# Heckington Fen Solar Park

EN010123

## Applicant Response to Deadline 1 Submissions

Document Reference: ExA.ResponseD1Sub-D2.V1

FIGURE 3.8 – Extent of Plantation clearance in Additional Works areas at Bicker Fen National Grid Substation

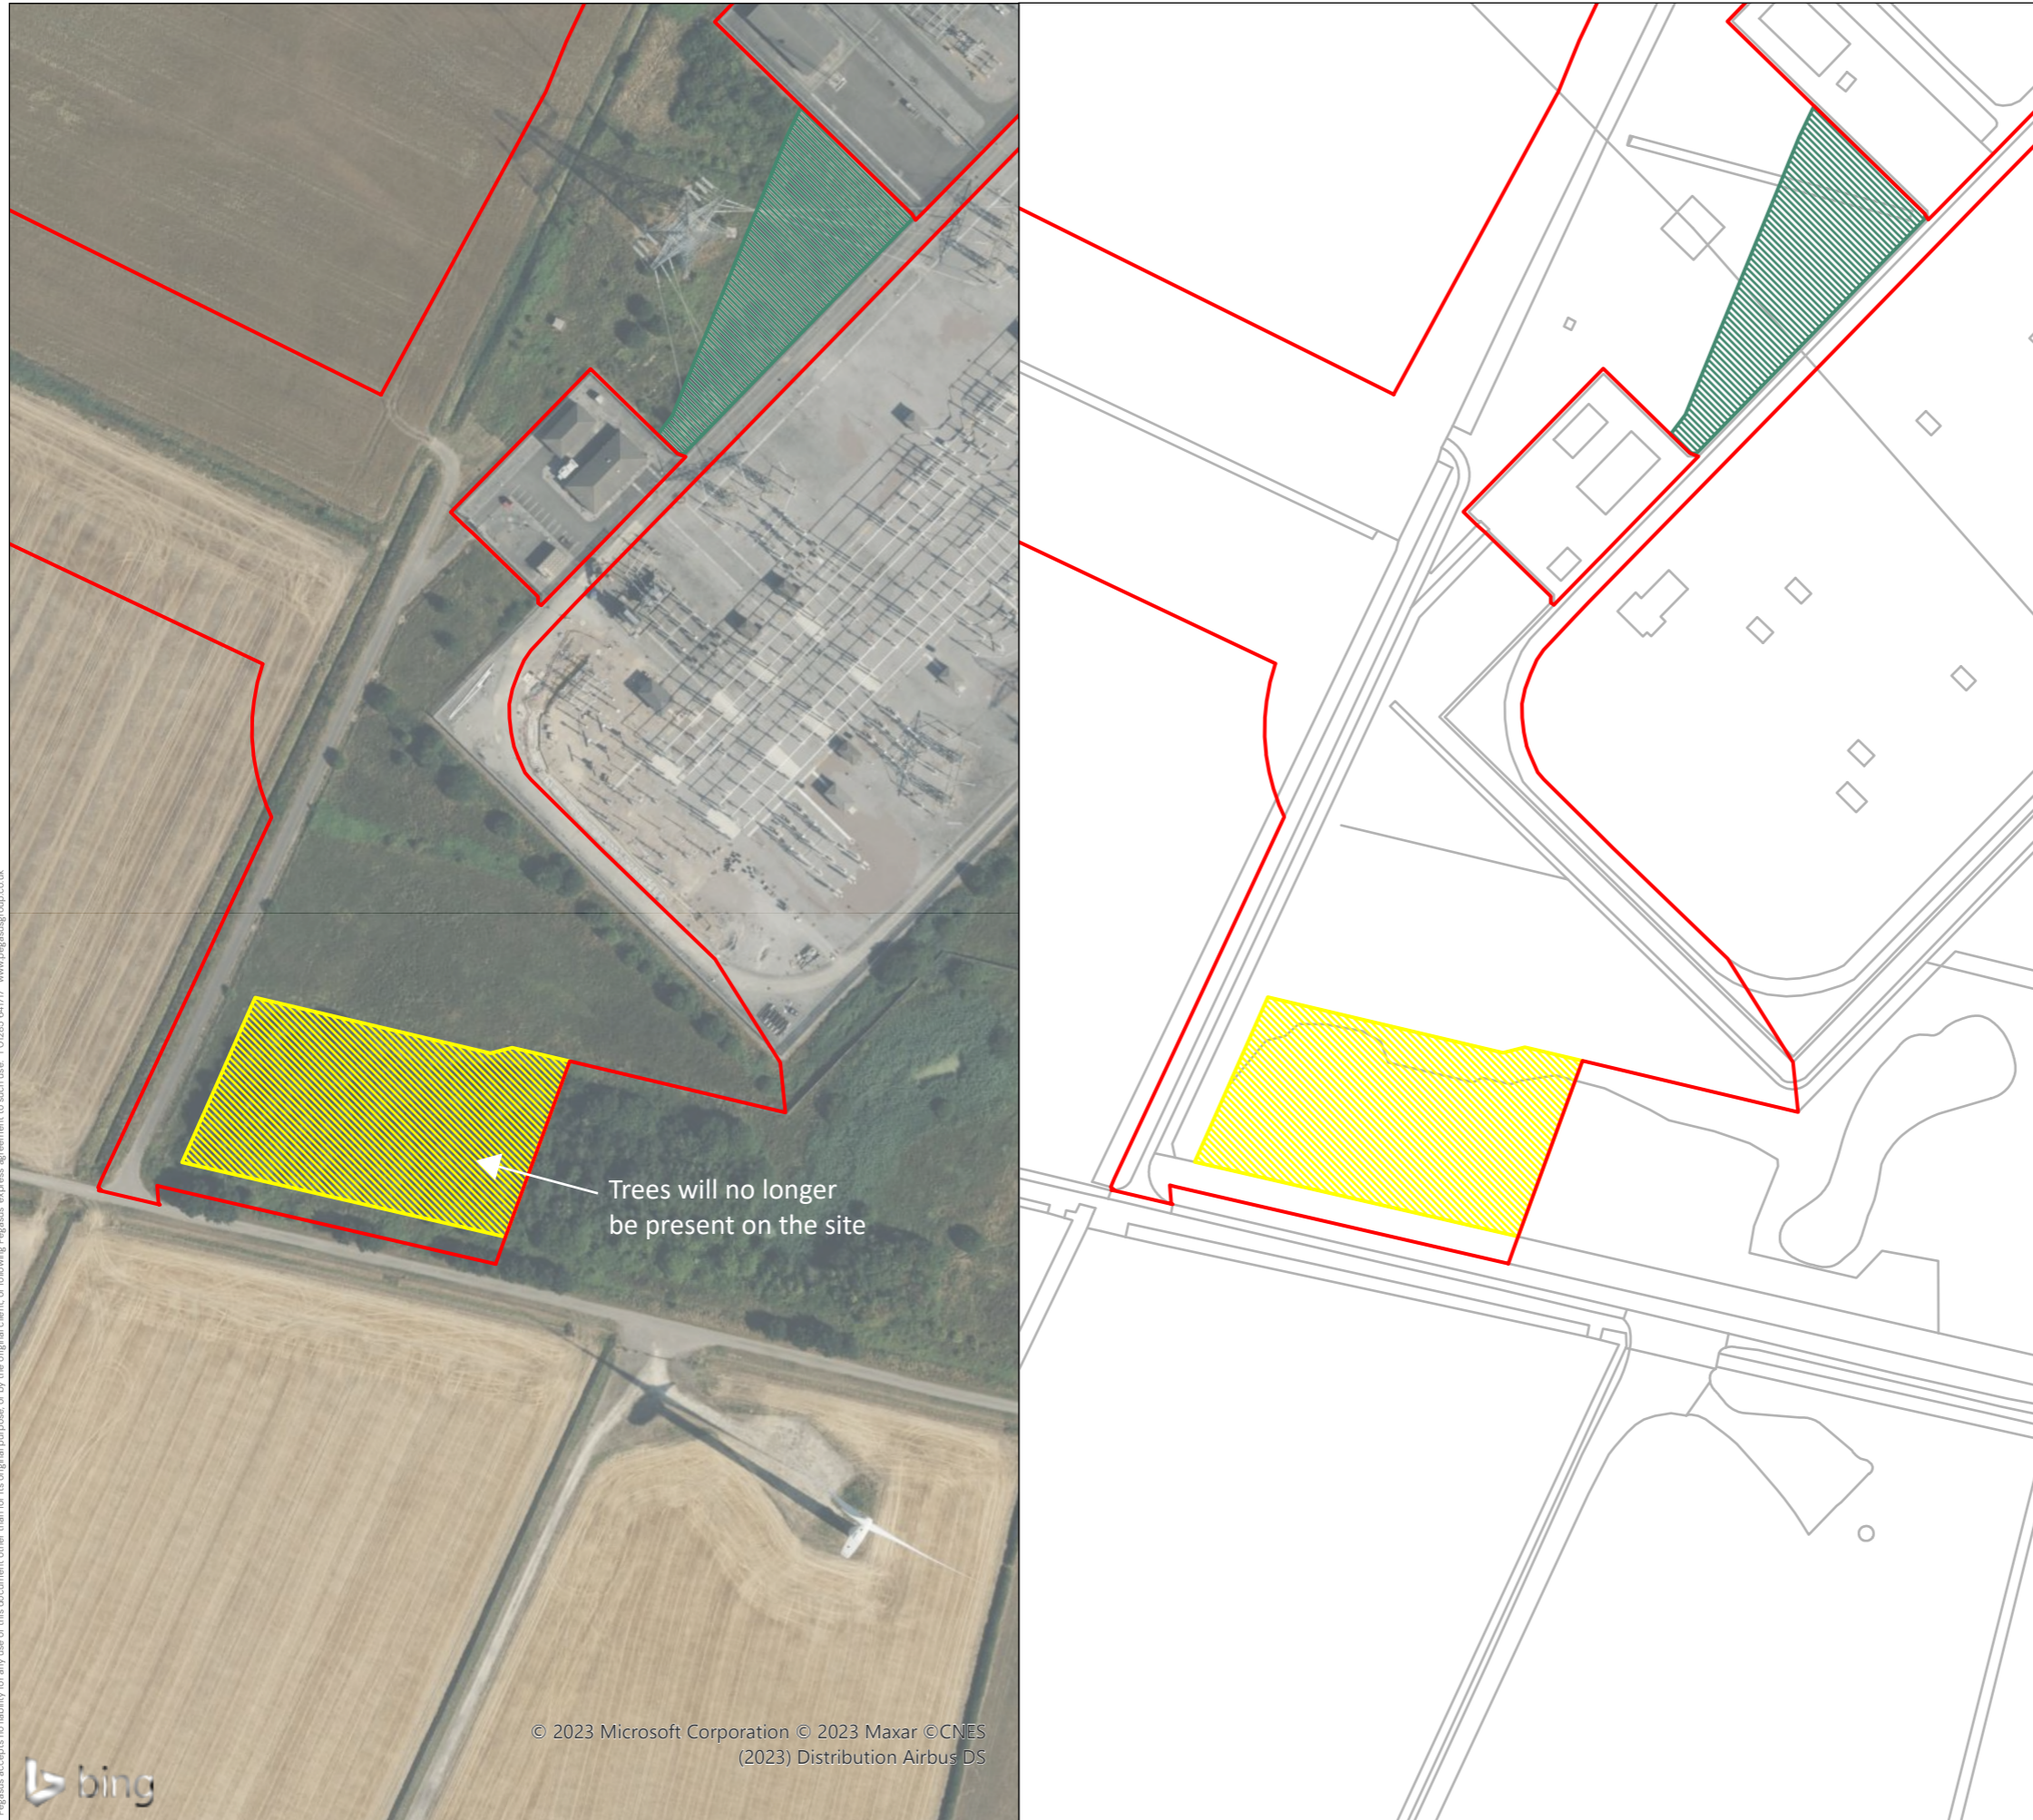
Theme	Consultee Comment (REP1-027)	Applicant Response
Biodiversity	Boston Borough Council in its LIR and its response to the Change Application for the works required at the Bicker Fen Substation have raised the loss of the trees at Bicker Fen Substation. This would be	The Applicant is working with BBC to try and lessen the impact of the tree removal. From a landscape character point of view the existing woodland W7 located immediately to the south of the National

Theme	Consultee Comment (REP1-032)	Applicant Response
Biodiversity	<p>The main additional habitat impact of note is the loss of 4ha [sic 0.4ha] of plantation woodland comprised of native tree species (the submitted plans indicate this would be over 50% of the affected woodland). The South East Lincolnshire Local Plan states (paragraph 7.5.11) that there is little woodland in South East Lincolnshire. AECOM do not agree with the assessment that the woodland is of local nature conservation value only. Given the scarcity of woodland in the Local Plan area, district/borough value would seem most appropriate in accordance with the method statement in Section 8.3 of Chapter 8 of the Environmental Statement (ES).</p>	<p>The Applicant notes this comment, and has proposed additional planting (0.42ha) in land it has control over for further planting. Following ongoing discussions with BBC this does not satisfy their concern and the Applicant is looking to overcome this with additional planting, but an area for this is not yet confirmed.</p>

Theme	Consultee Comment (REP1-027)	Applicant Response
	<p>harmful in terms of character, screening and ecology impacts.</p>	<p>Grid Bicker Fen Substation, is considered to be of low value with its function being primarily a mitigation planting associated with the planning permission for the Bicker Fen Substation which was approved in 2005 (under Boston Borough Council reference B/05/0046), and not associated with the traditional field pattern. It adds to the amount of tree cover in the landscape, helps interrupt and screen views, but is a recent man-made feature and only appreciated from a very limited number of public vantage points. In other words, it adds very little to the overall landscape character. In terms of ecology, whilst the woodland compartment has some localised structural value in terms of providing connectivity within and around the substation it is considered to have a limited value in terms of ecological functionality, mainly due to the woodland compartments age and current unmanaged state. Therefore, its partial removal is not considered to be materially harmful / or significant in terms of ecological function and landscape character.</p>

HECK-SP22/HECK-AFP011
Compensatory Tree Planting

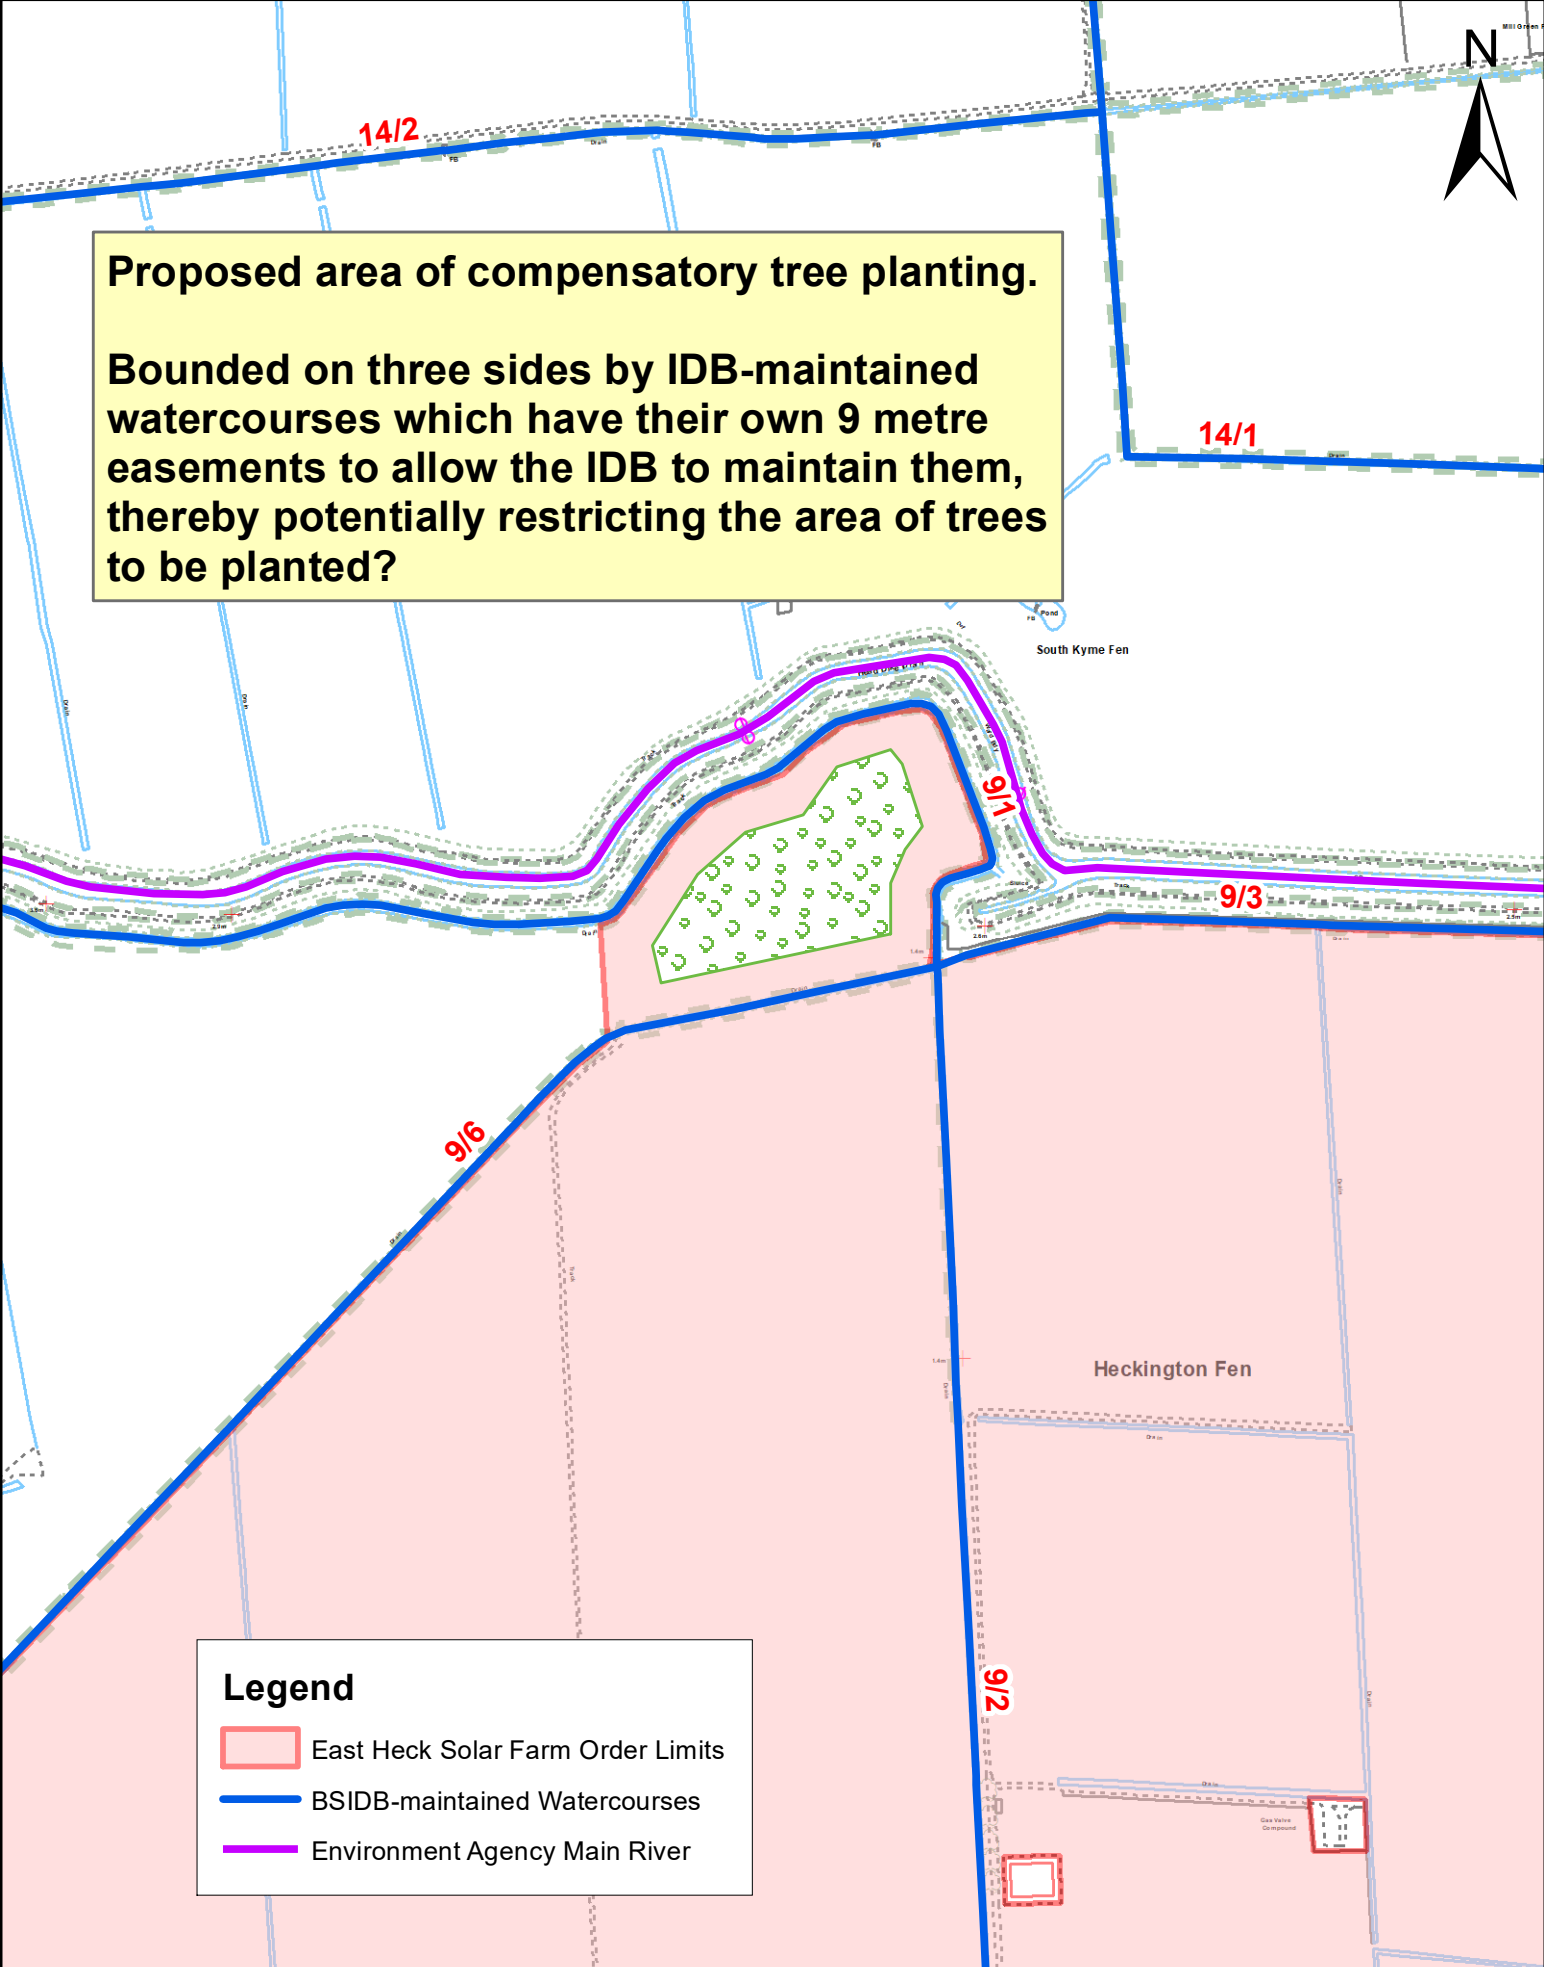
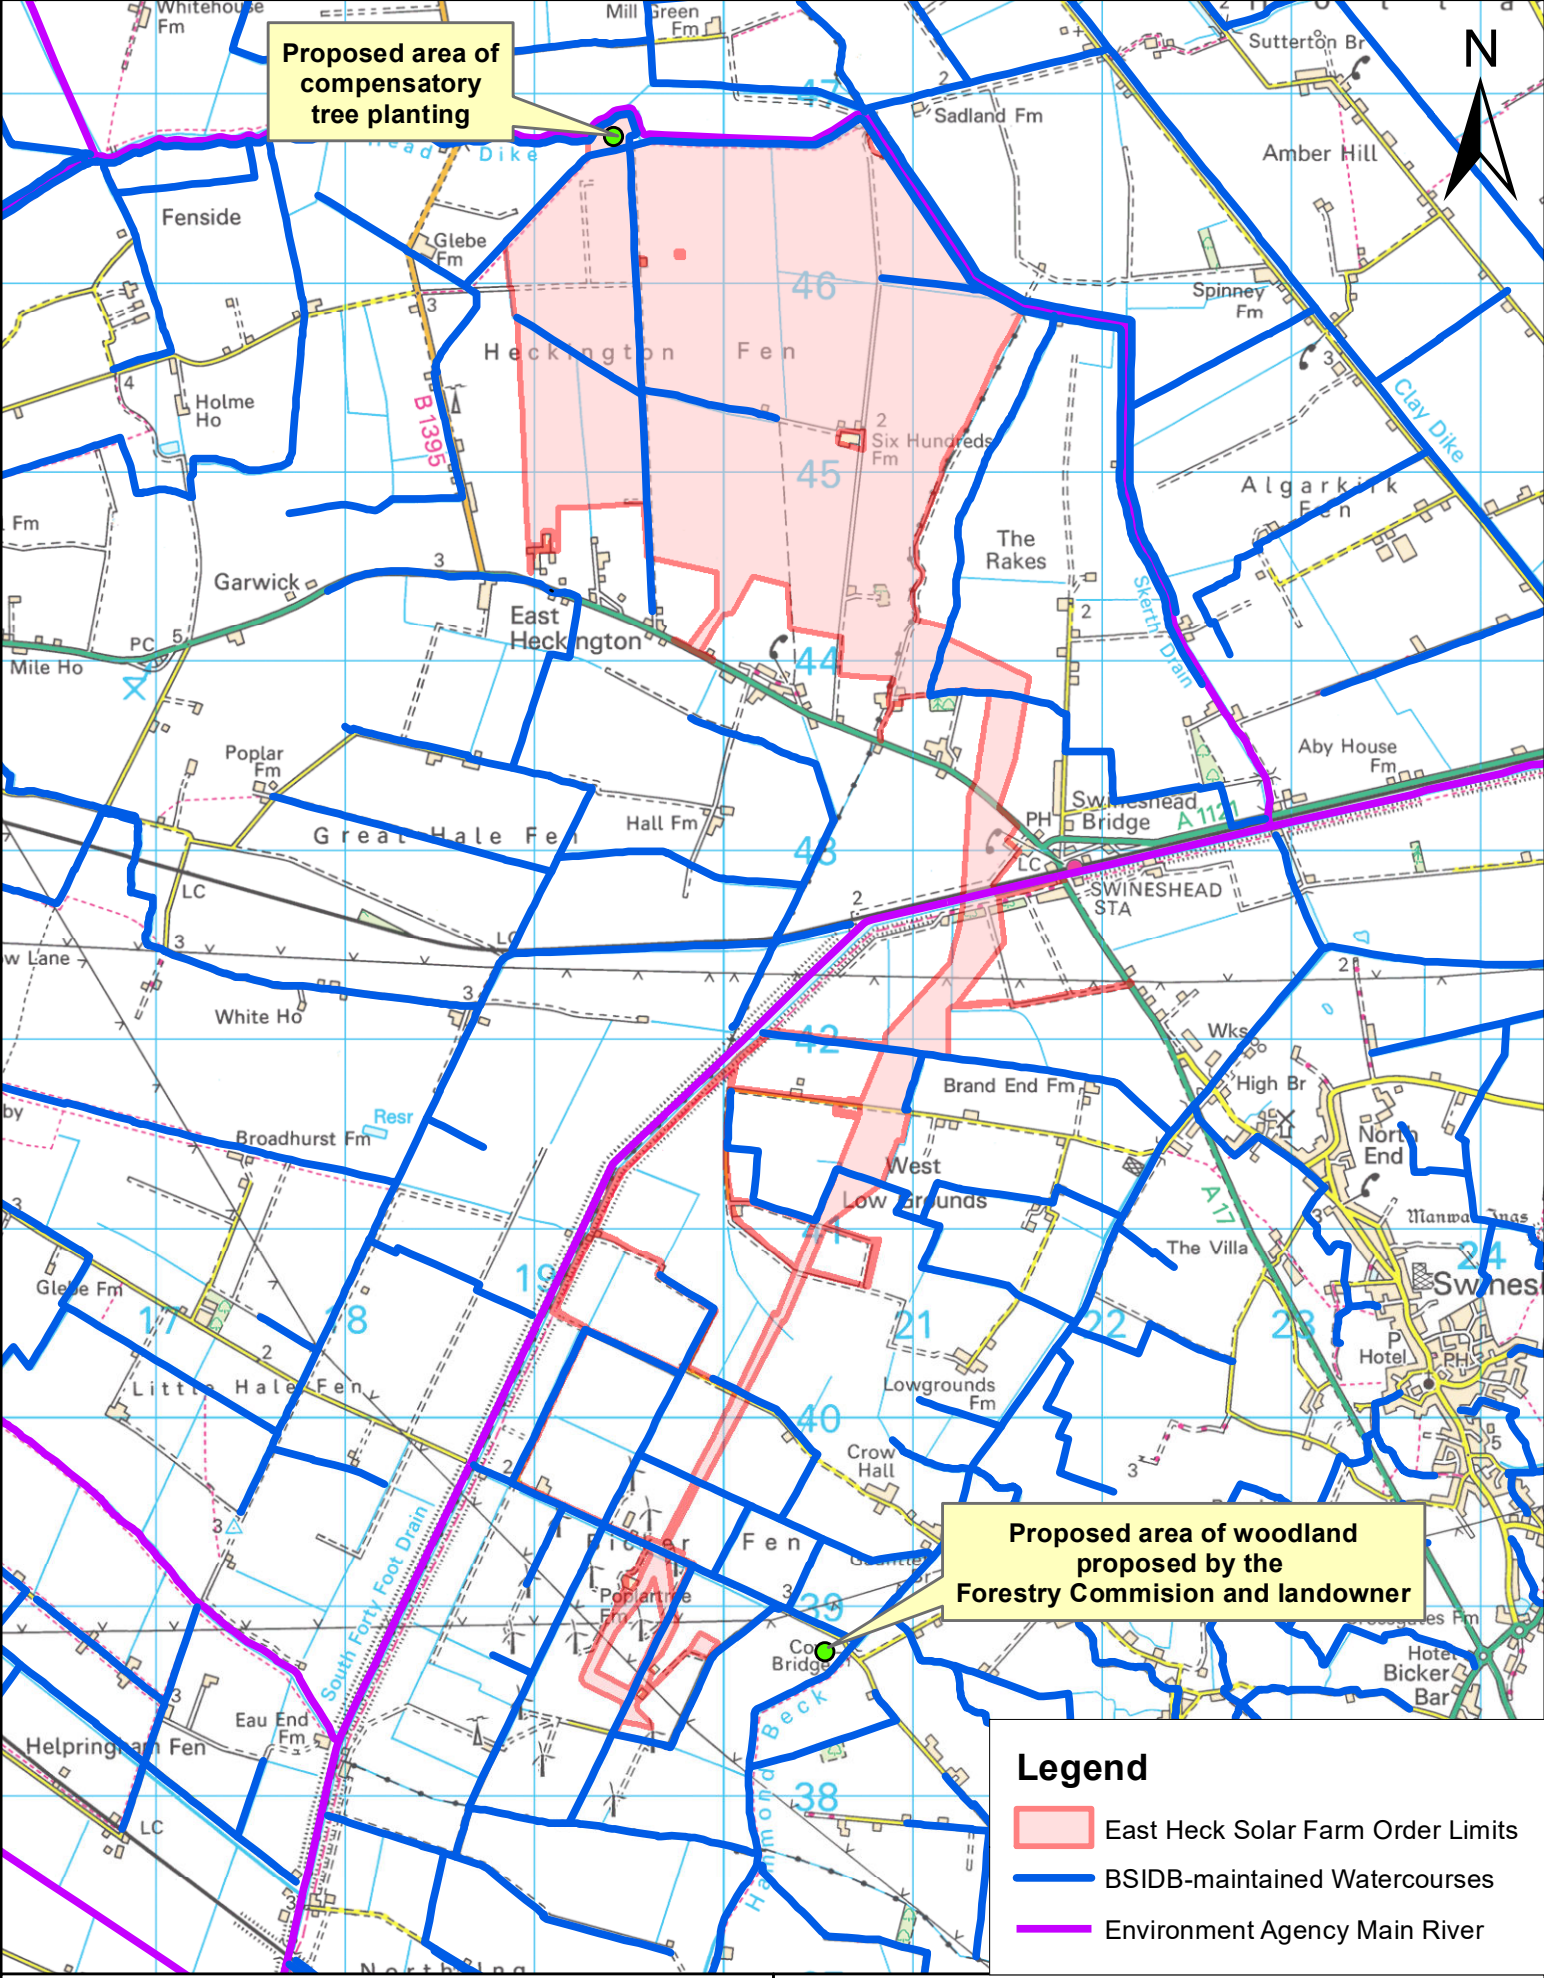
Biodiversity	Map 1 with the text: <i>"Proposed area of compensatory tree planting. Bounded on three sides by IDB-maintained watercourses which have their own 9 metre easements to allow the IDB to maintain them, thereby potentially restricting the area of trees to be planted?"</i>	The area for tree planting is proposed on Figure 6.2- Landscape Strategy (document reference 6.2.6/PS-091) and OLEMP (document reference 7.8/PS-148). The proposal incorporates the 9m setback for the IDB watercourses. The area for planting shown on the BSIDB Map includes a larger area of proposed planting, and a wider buffer of approximately 25m.
Biodiversity	Map 2 with the text: <i>"Proposed area of compensatory tree planting"</i> and <i>"Proposed area of woodland proposed by the Forestry Commission and landowner"</i>	The Applicant thanks BSIDB for this information.
Biodiversity	Map 3 with the text: <i>"Proposed educational area with 'dipping pond'"</i>	The Applicant thanks BSIDB for this information.
